From: [Mike Flory](#)
To: [Rachael Stevie \(CD\)](#)
Subject: RE: VA-21-00003 Ward - Notice of Application
Date: Friday, February 26, 2021 9:50:40 AM
Attachments: [image001.png](#)

CDS Building does not have any concerns with this setback variance request.

SITE PLAN

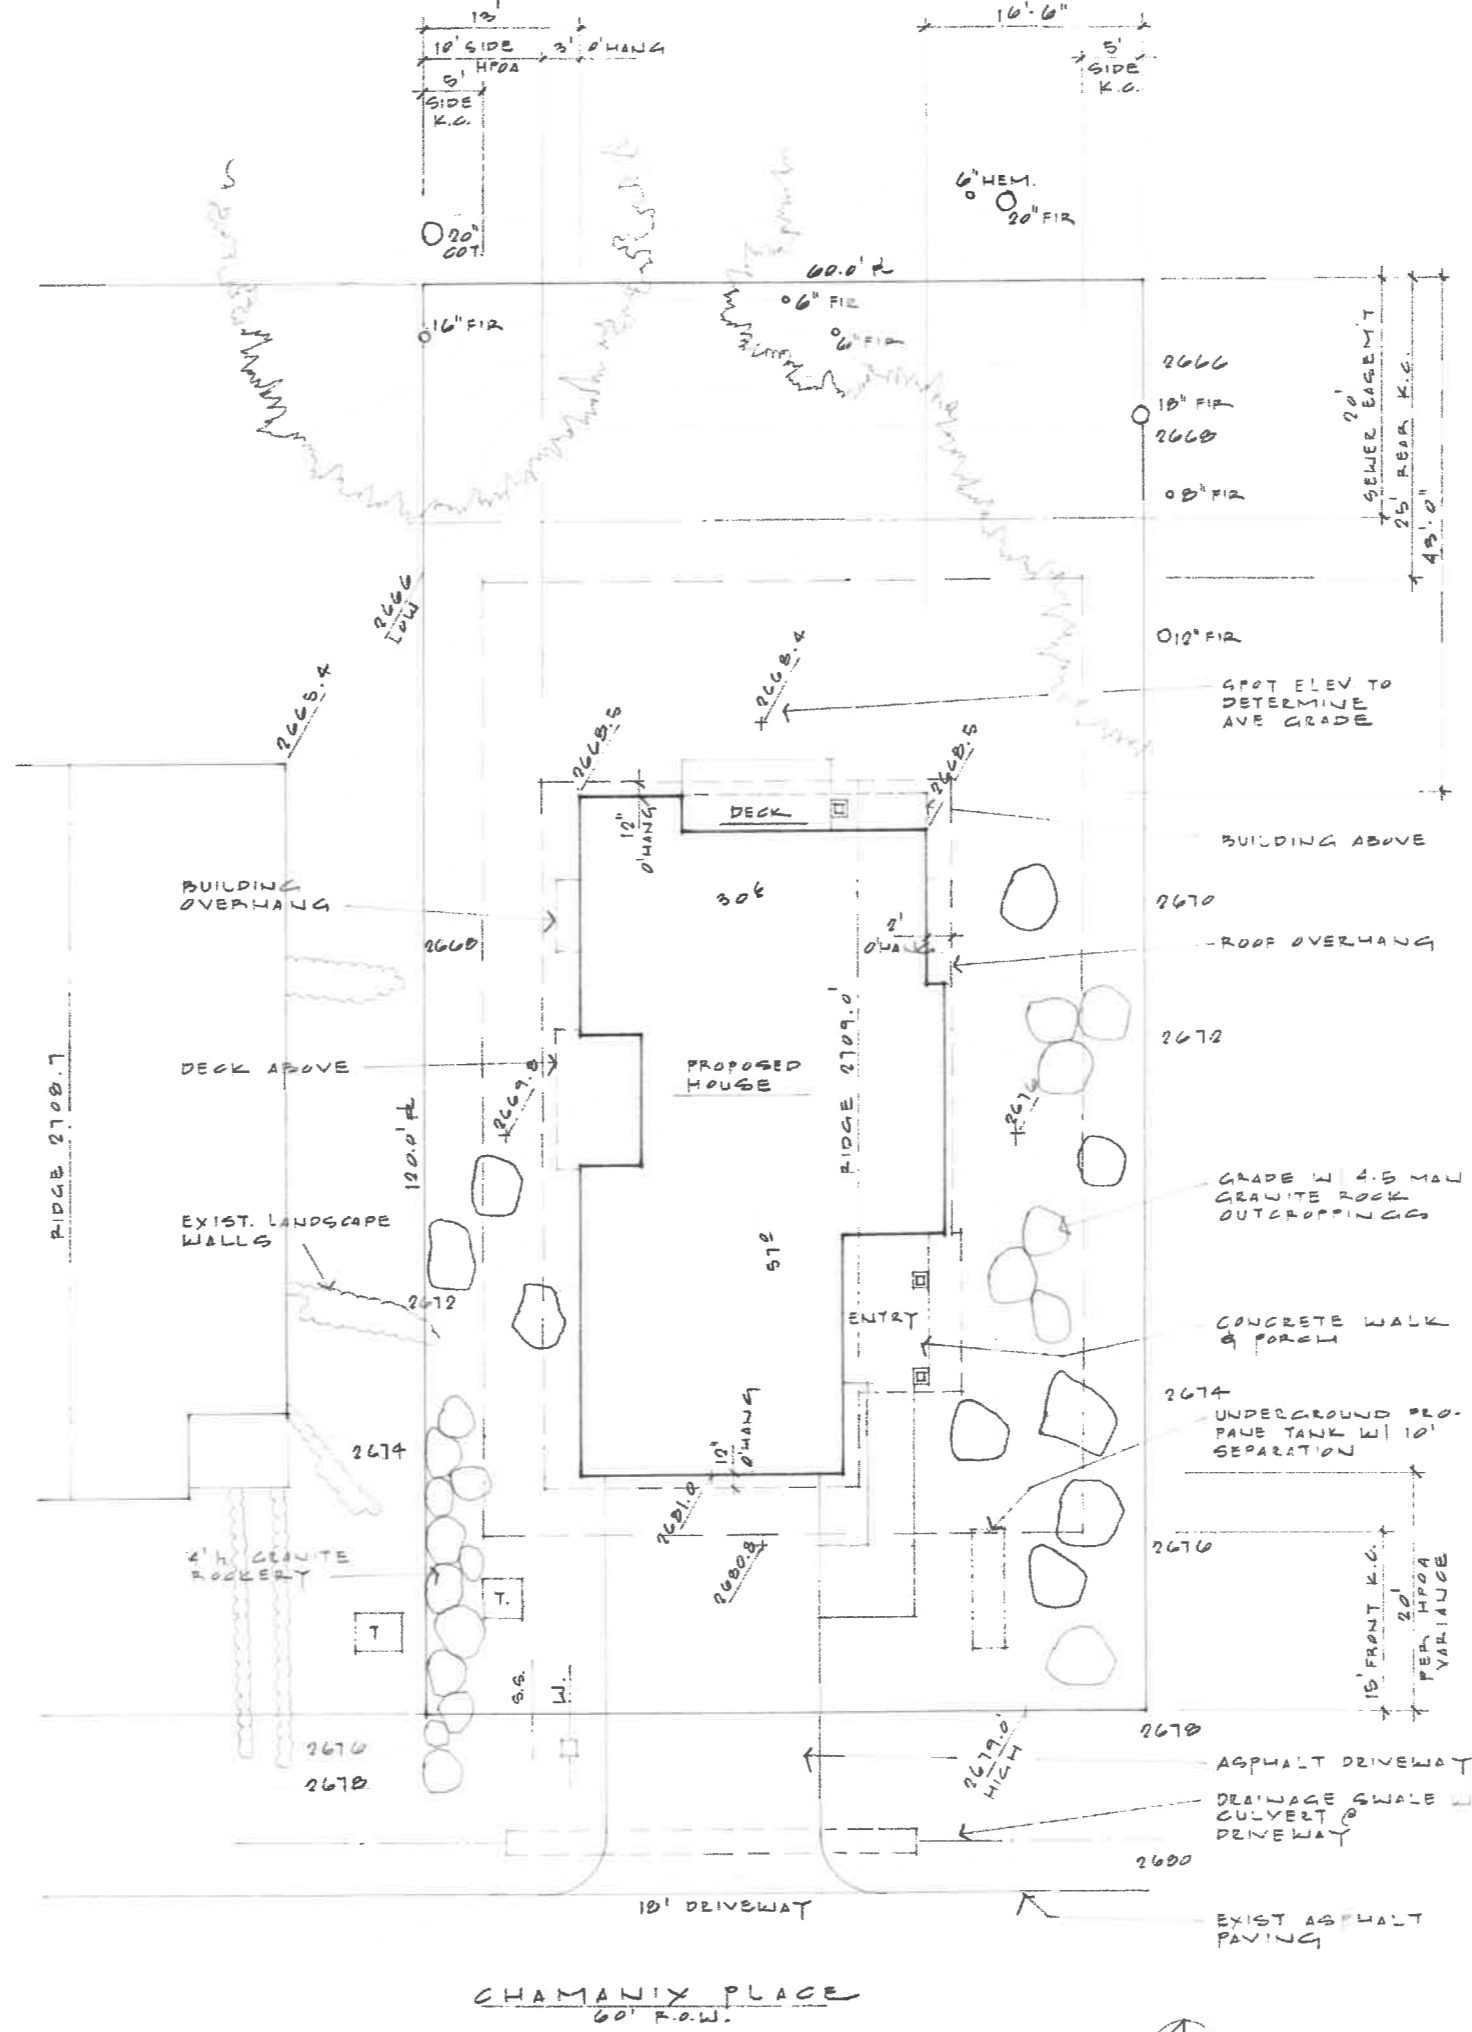
I do want to note that the site plan shows an underground propane tank and that does need to meet proper setbacks to property lines per the NFPA 58.
